## **Nathan Stringer - Epping to Thornleigh Third Track proposal - submission**

Director - Infrastructure Projects  
Epping to Thornleigh Third Track Project - SSI 5132  
NSW Department of Planning and Infrastructure  
GPO Box 39  
Sydney NSW 2001

### **Epping to Thornleigh Third Track proposal - SSI 5132**

Figure S.6 Cross-section and elevation - New Cheltenham Station concourse building (see also S.5 for artist's impression)

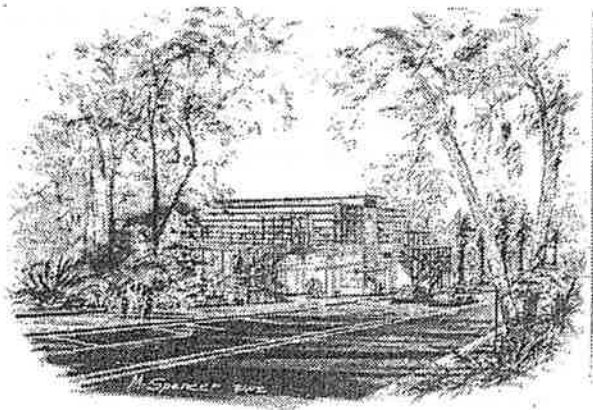
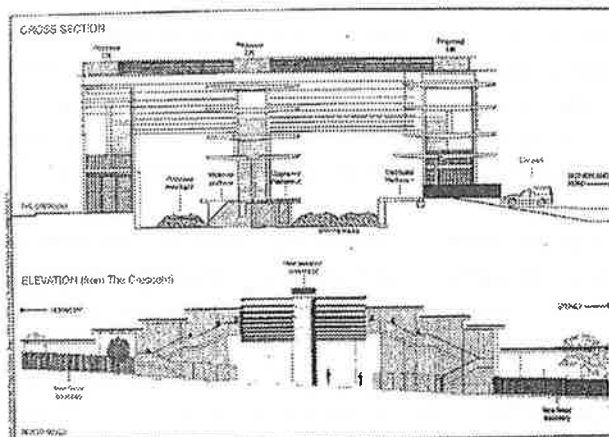
However i object to the current proposed design for upgrading Cheltenham station, because:

1. The proposed structure is out of scale with the surrounding residential buildings. Its large size will intrude into and dominate the surrounding streetscapes.
2. The modernist airport-terminal architectural style for the proposed overhead concourse is inappropriate to the surrounding styles of house construction.
3. Lifts 1 and 3 are unnecessary. Lift 2 and its accompanying stair should be relocated to beside the Cheltenham Road road overbridge so utilising the existing footpath on the Sydney side of the bridge to access platform 2. This would obviate the need for the new overhead concourse, and save its cost plus the cost of two lifts.
